(Your Ref: MP10\_0177 MOD 7)

**RE: COUNCIL SUBMISSION TO MP10\_0177 MOD 7, APPLICATION FOR MODIFICATION OF MAJOR PROJECT APPROVAL UNDER SECTION 75W**

CARPARK LEVEL

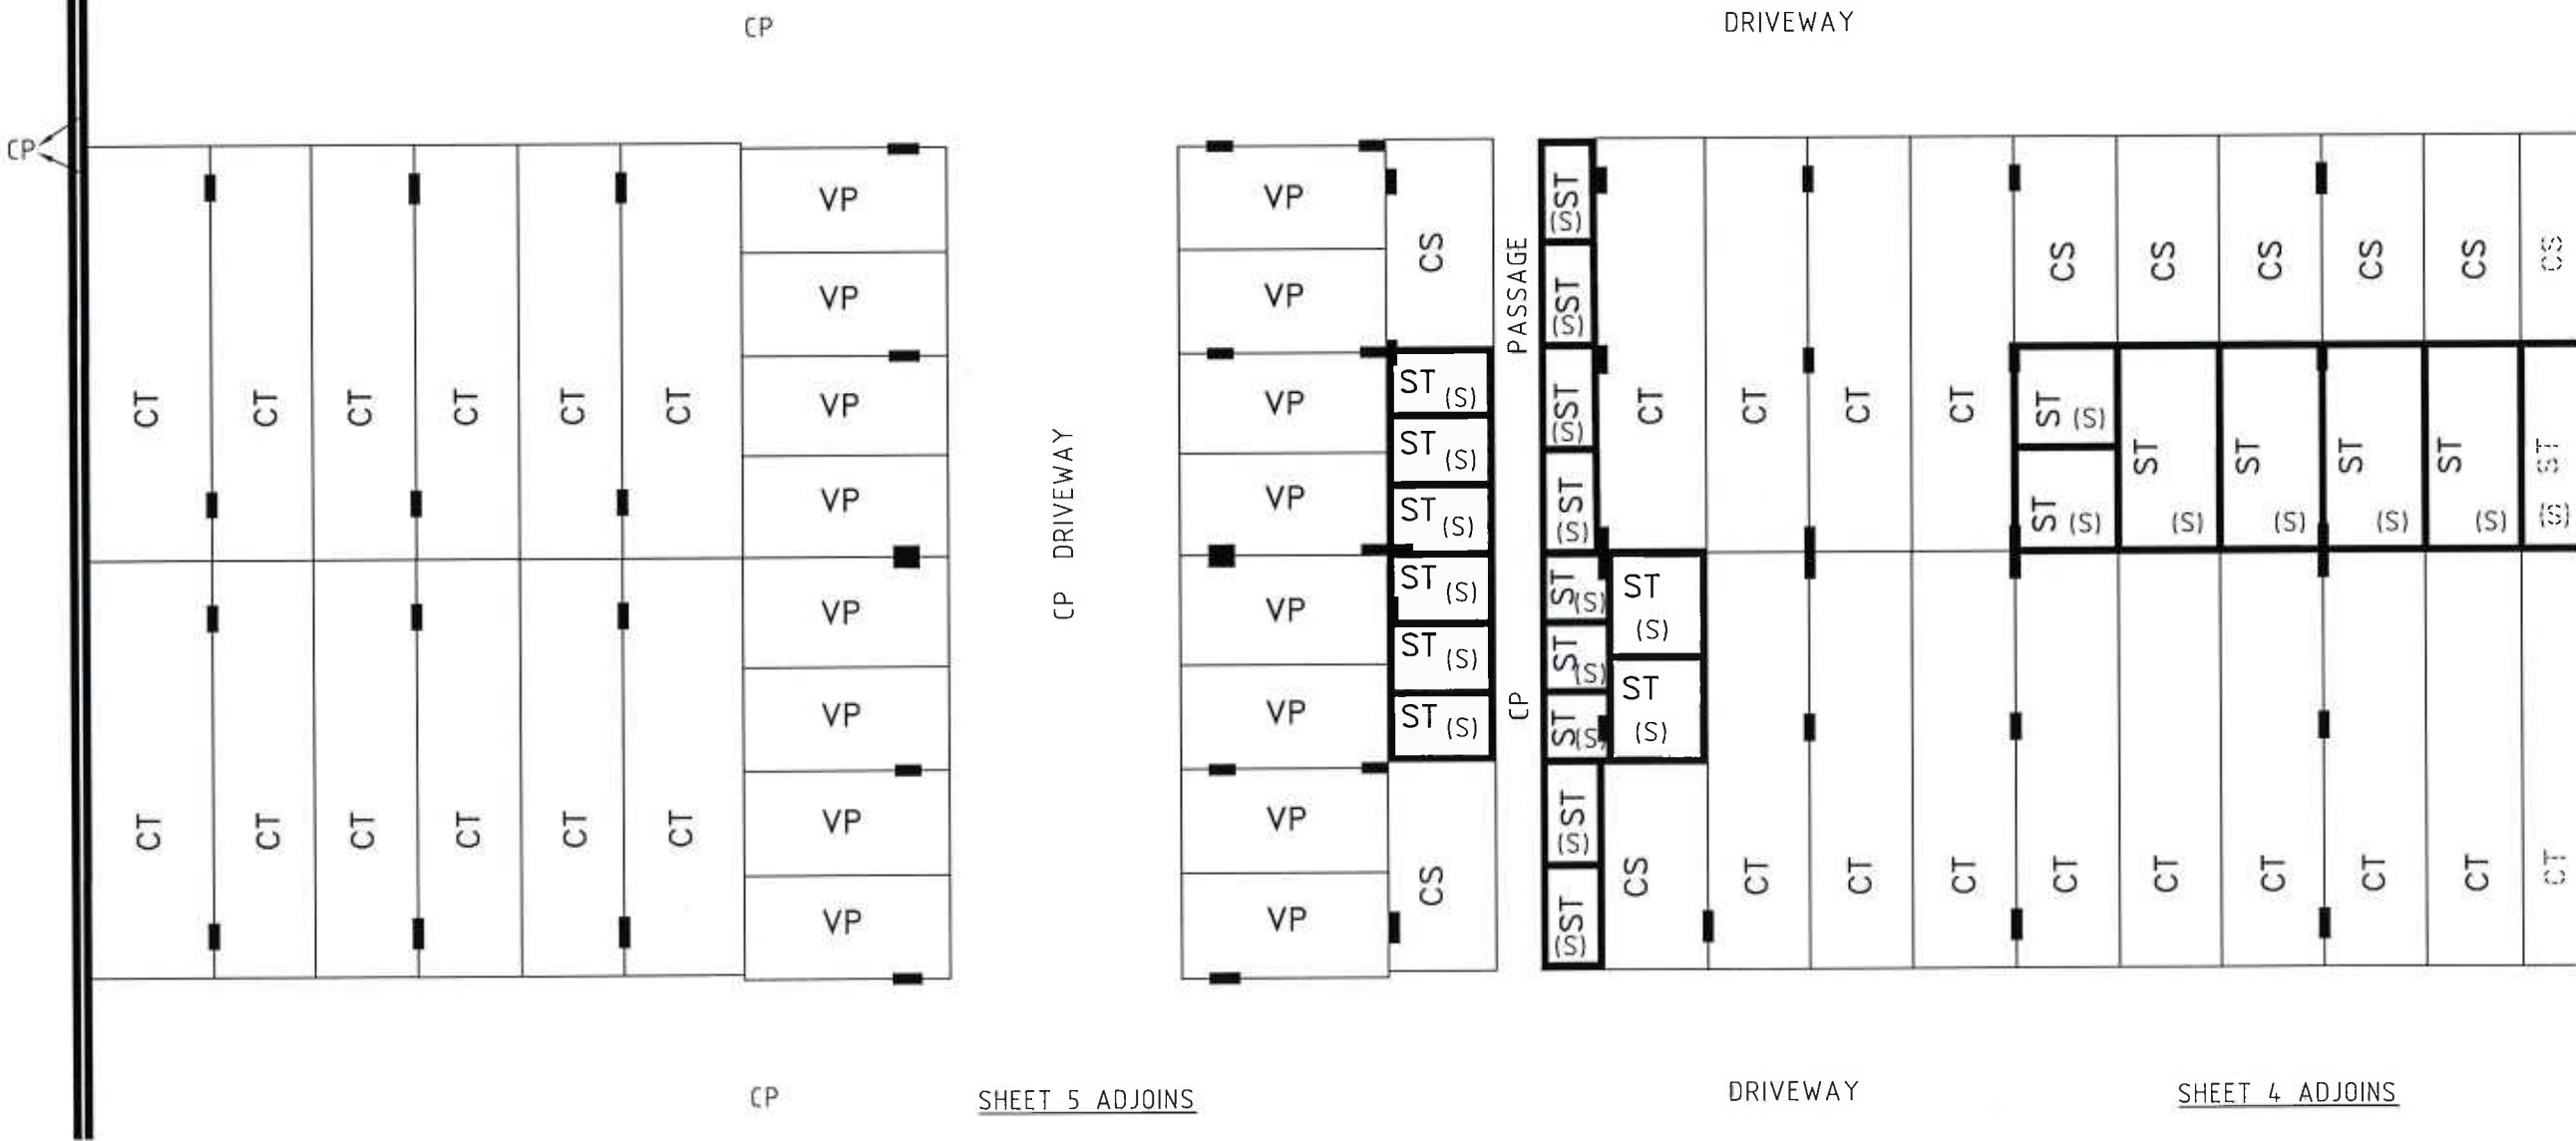
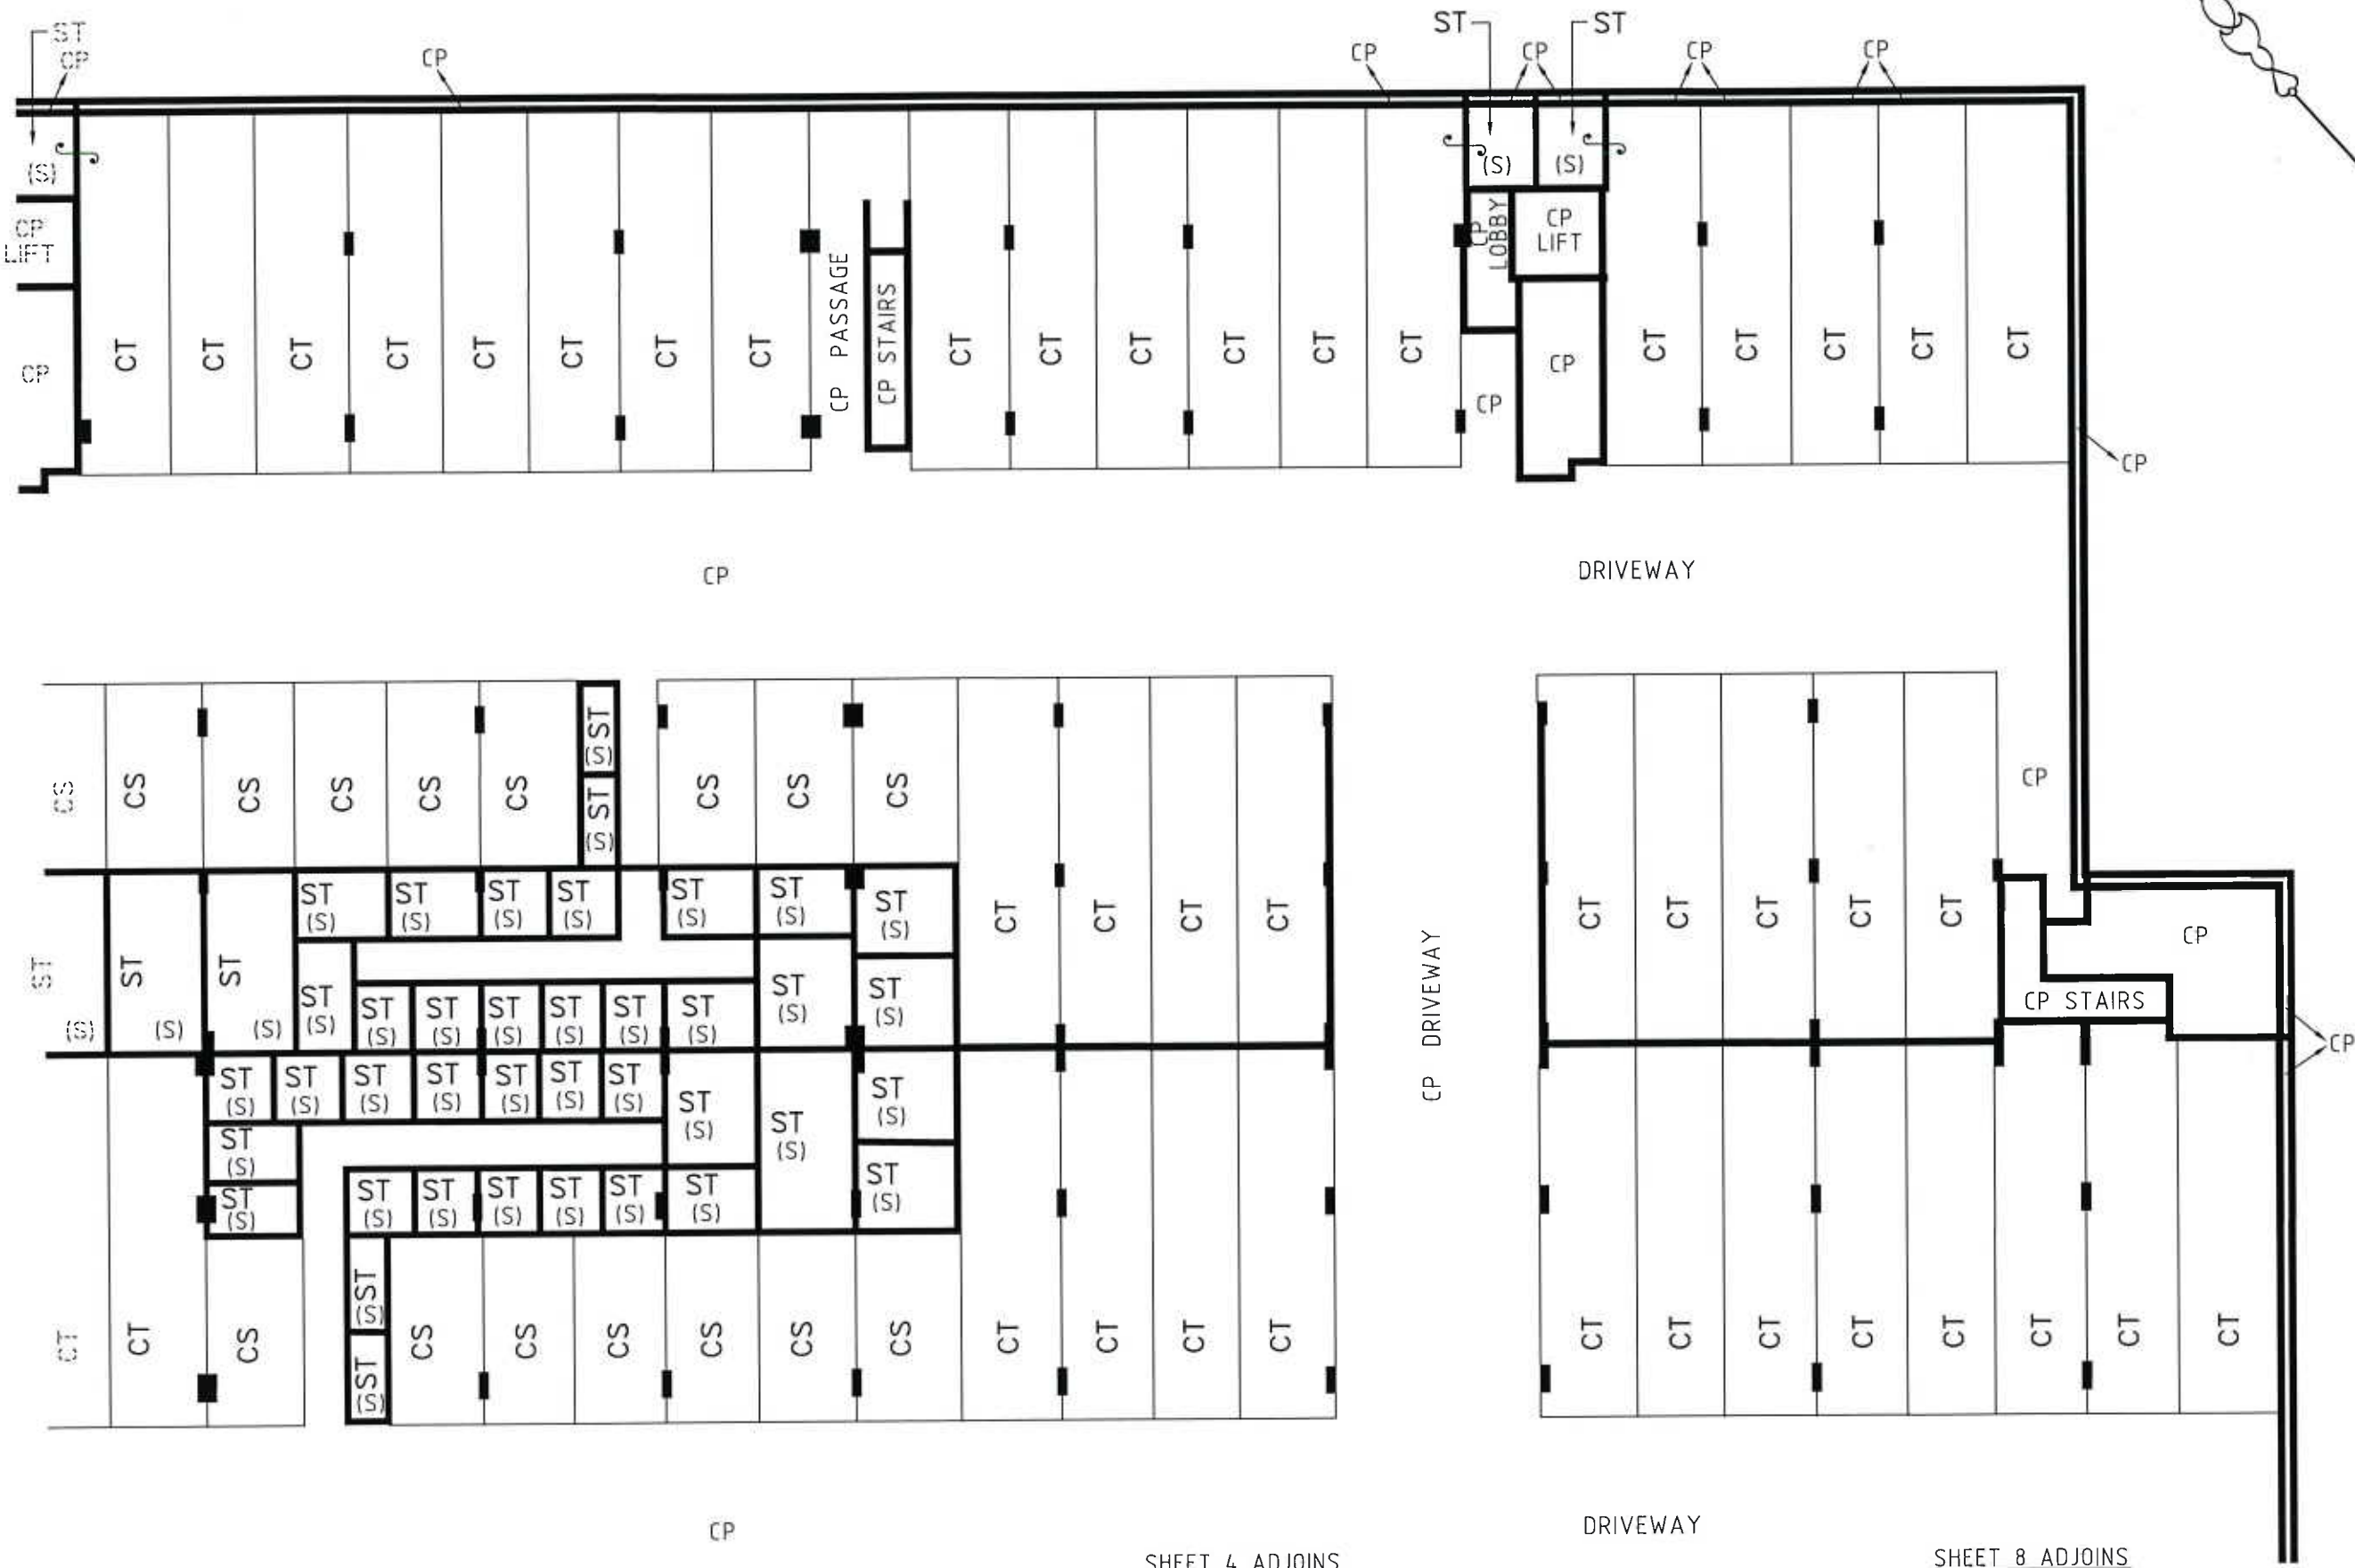
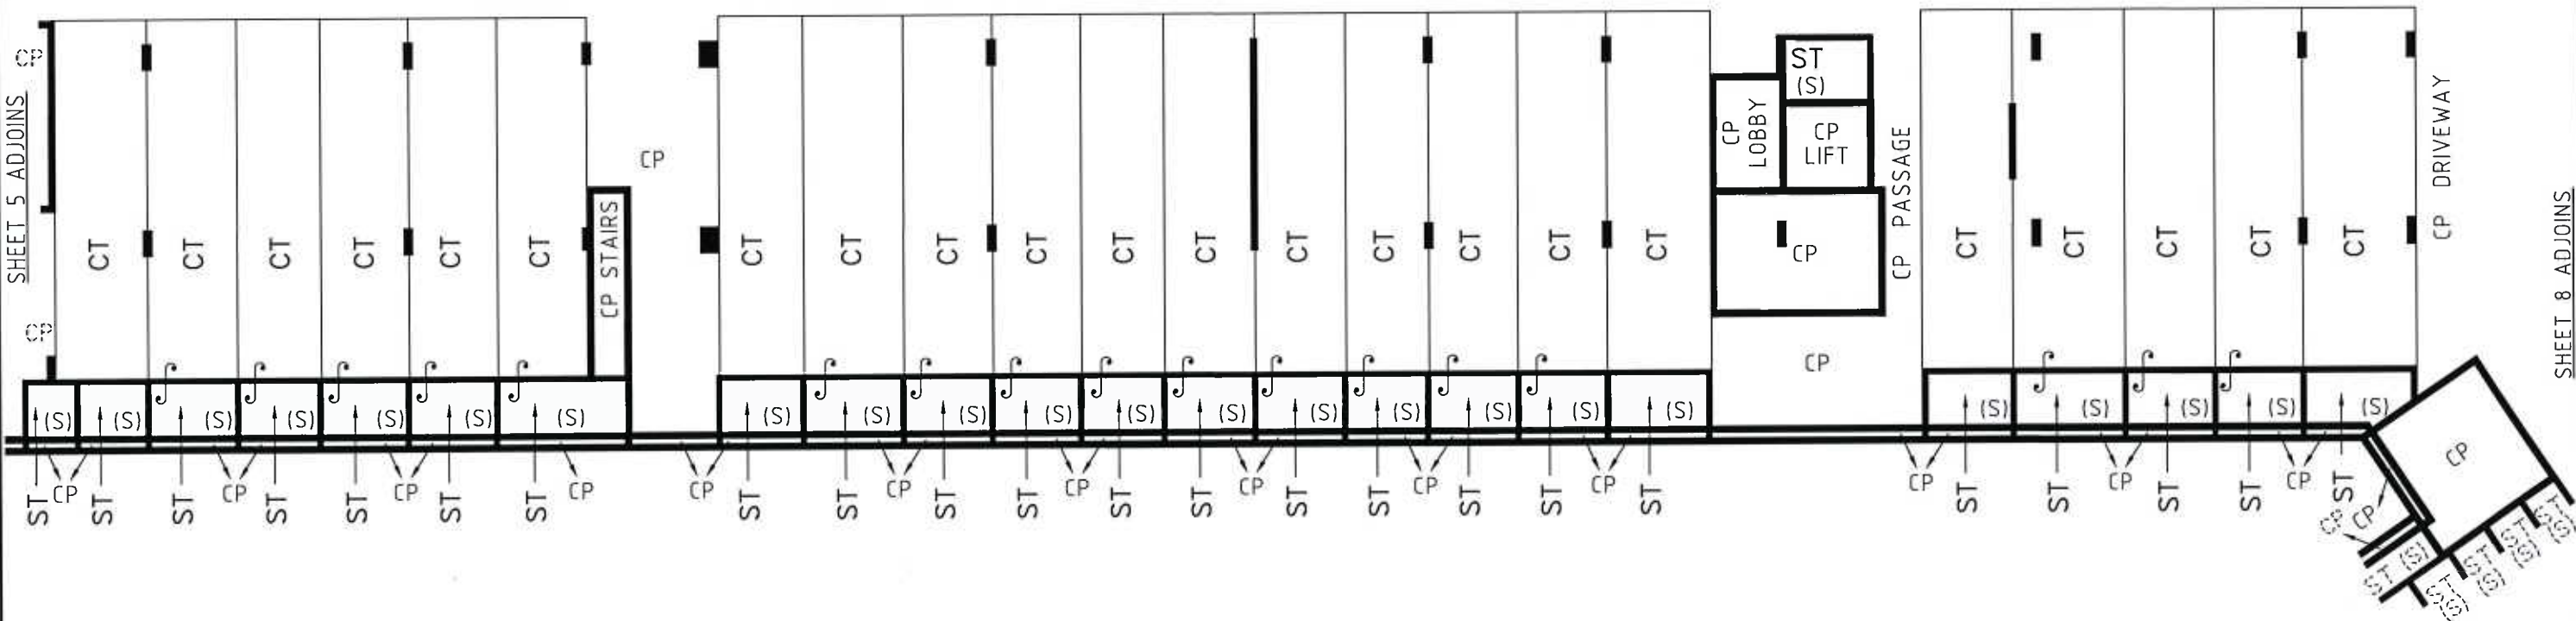
- a) Each dwelling being provided with a car parking space(s) commensurate with the number of bedrooms contained in the dwelling and storage area within the single level basement in accordance with Condition B13 (as amended). The 46 visitor parking spaces, spaces for emergency and delivery vehicles and a space for car washing, and bicycles spaces are not allocated to individual dwellings through the subdivision and must be "Common Property" readily available for use.

*Any future strata subdivision of the subject site must respect the car parking and storage area allocation approved in accordance with Condition B13. Prior to the release of the approved linen plan of subdivision, the parking spaces (with the exception of the the 46 visitor parking spaces) and storage areas in the single level basement are to be allocated to each dwelling, to be shown as Part Lot rather than individual lots in the linen plan. The remainder of the basement parking level comprising 46 visitor parking spaces, spaces for emergency and delivery vehicles and area for car washing, bicycle spaces, garbage areas, vehicular ramps etc. to be shown as 'Common Property' and must not be individually allocated by the subdivision or any by-law or other mechanism.*

*Prior to the release of the approved linen plan of subdivision, a restrictive covenant is to be created to the effect that the residential and visitor parking spaces including spaces for emergency and delivery vehicles and car washing are not to be used in a manner inconsistent with the Project Approval (as amended). The covenant is to be created appurtenant to, at no cost to and to the satisfaction of Council and shall include a condition that the covenant cannot be varied, modified or released without the prior approval of Pittwater Council. The covenant is to be lodged with the Land and Property Information Office at the same time as the linen plan of subdivision is lodged. Any future strata subdivision of the site is to include a restriction on user burdening all utility car parking allotments in the strata plan and/or an appropriate restrictive covenant burdening all car parking part-lots in the strata scheme.*
